Letter No.PP/NHRB/N/939/2019, Dated: 12.12.2019

Sub: CMDA – Area Plans Unit - 'B' Channel (North) - Planning Permission Application for the Existing construction of Stilt part/ Ground Floor part + 2 Floors + 3rd Floor part Kalyana Mandapam at sub divisional PP Plot No. 2A in PPD/ LO No.TNHB G-3/2019 Kalyana Mandapam comprised in S.No.582/2 part of Ambattur Village – Remittance of DC & Other charges – Revised DC advice Sent – Reg.

SITE / STILT / GROUND FLOOR (PART) PLAN

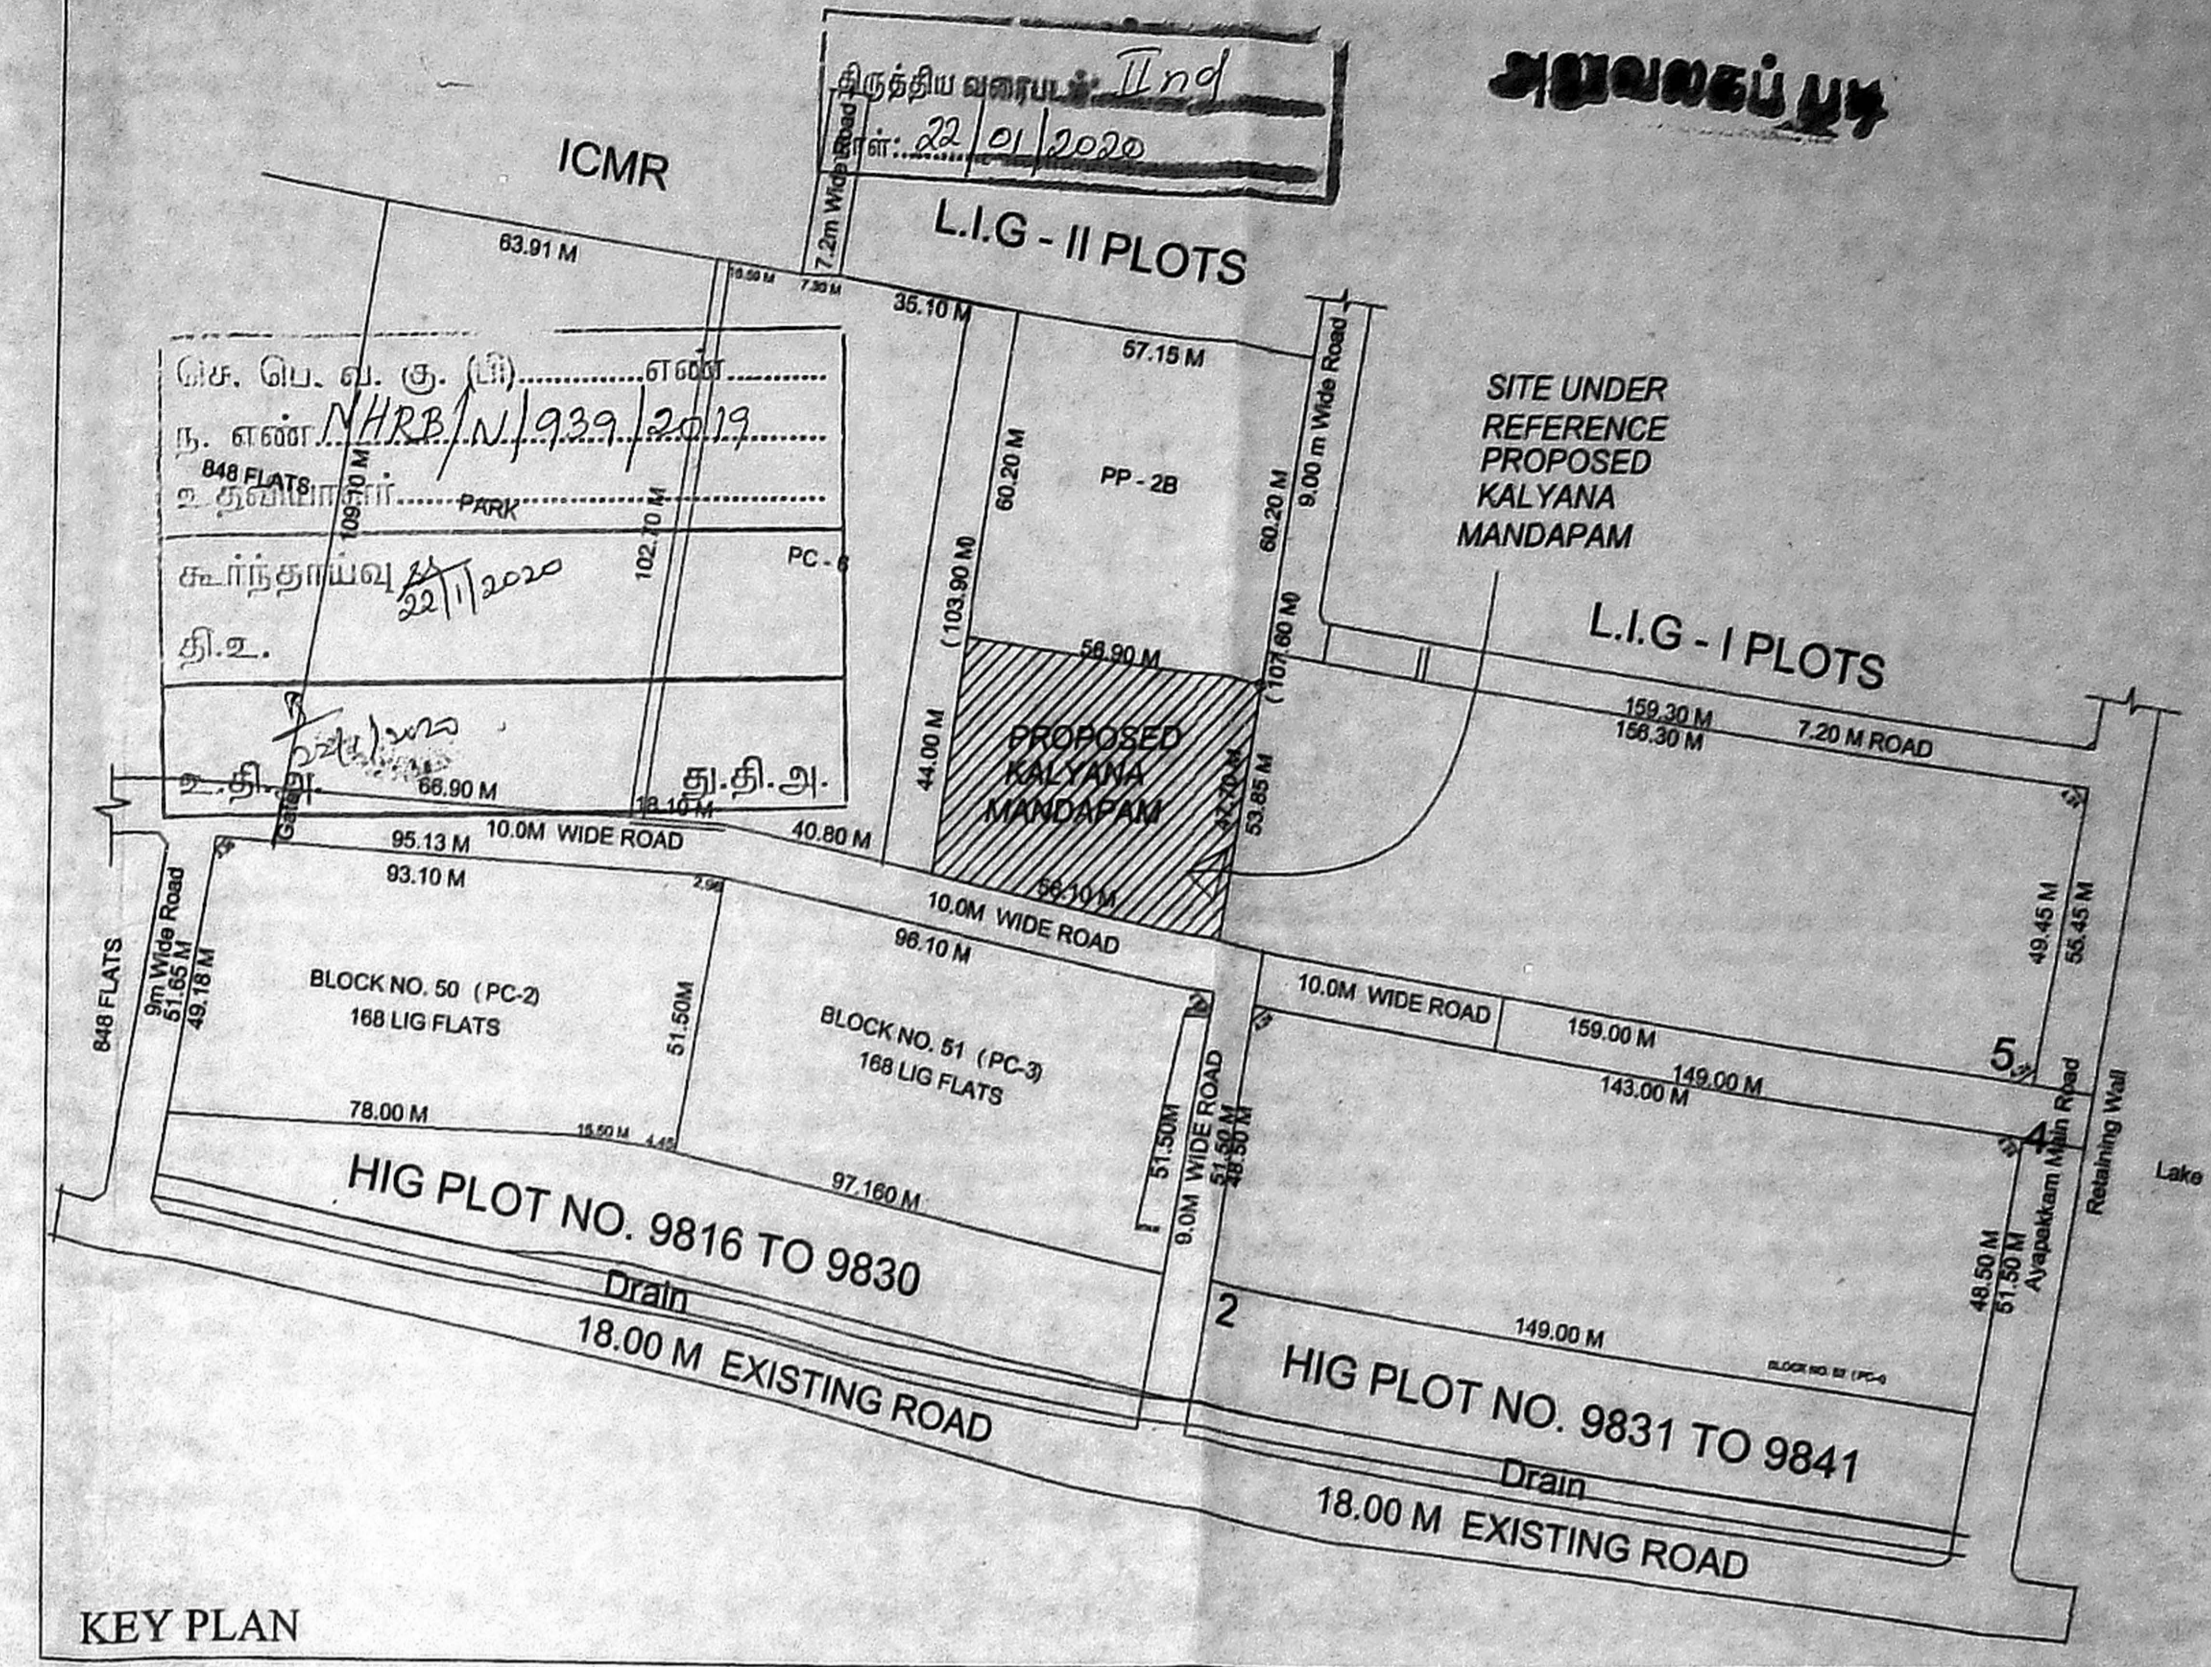
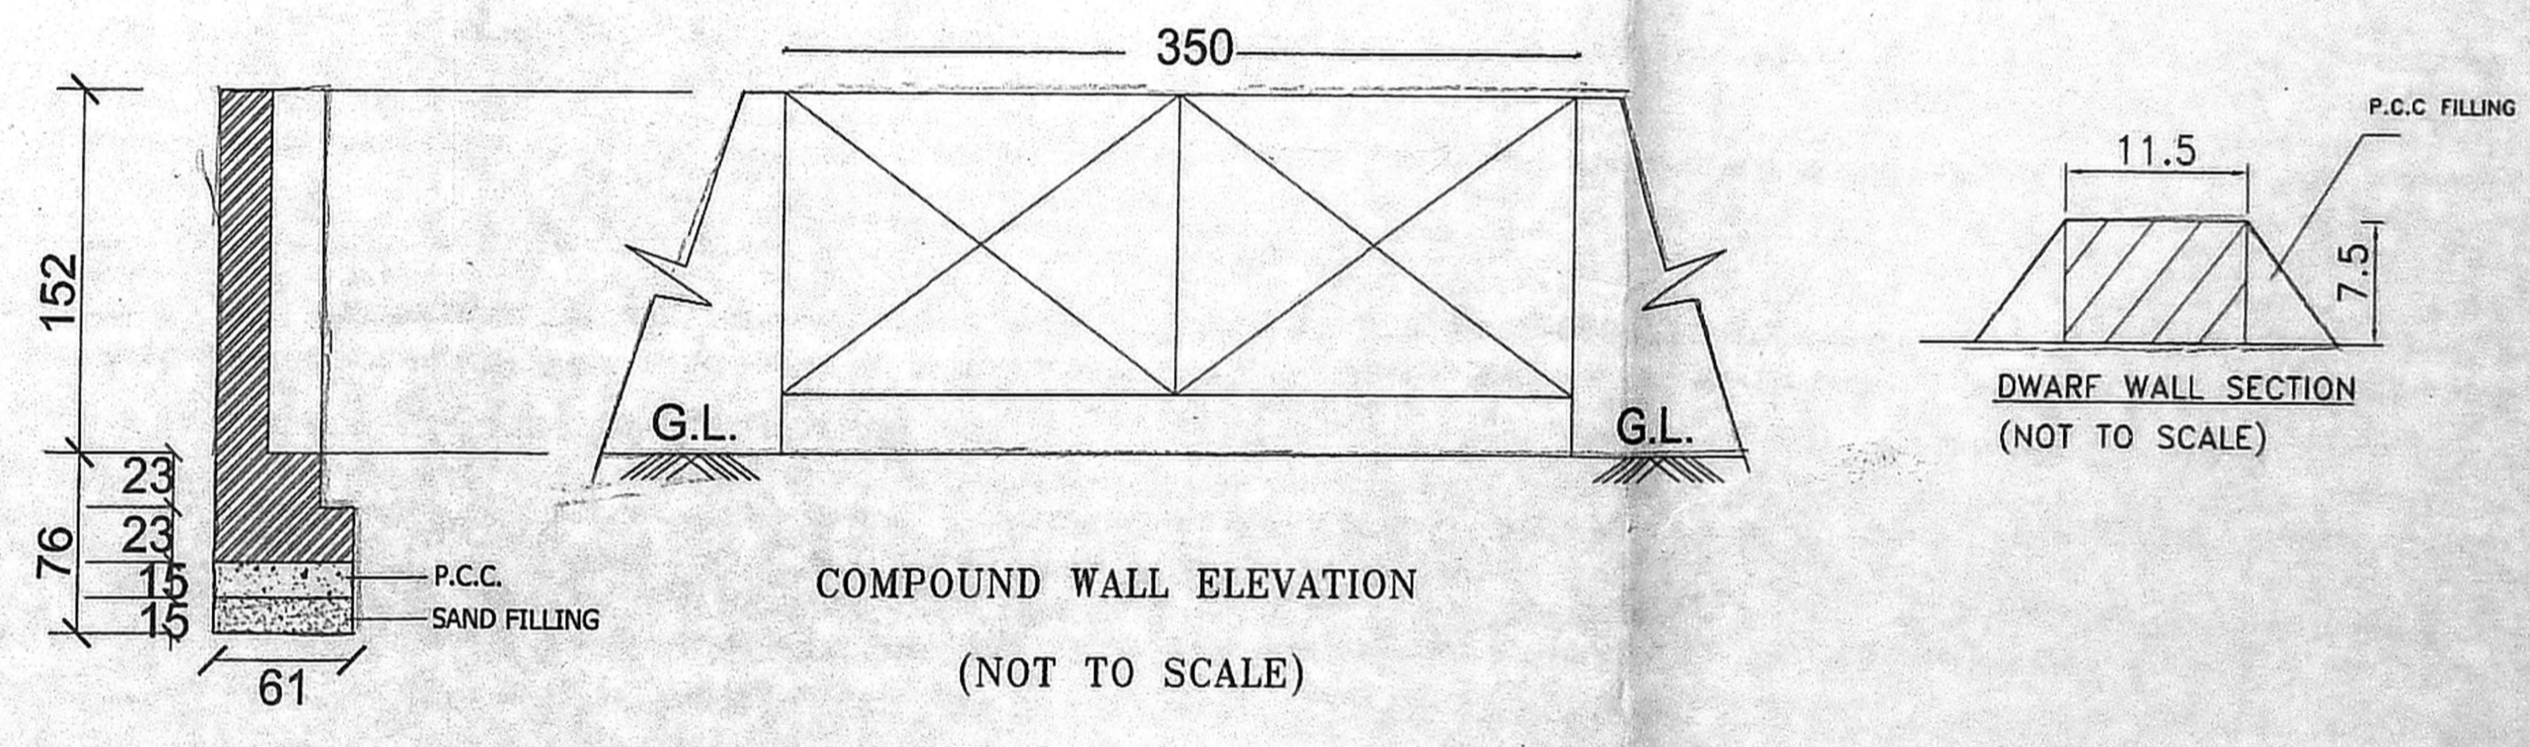
5. Area statement and title of the drawing requires correction.
 6. Certificate from qualified professional for providing Septic Tank with up flow filter and same to be shown in sit plan.

7. Rain water harvesting to be provided as per TNCDBR.
 8. Undertaking to accept the conditions put forth in the PWD, NOC letter to be furnished.
 9. Site plan is to be drawn showing dimensions both as per Patta and as on site conditions and distinguishing the difference by hatching and indicating the setbacks from least boundary line.
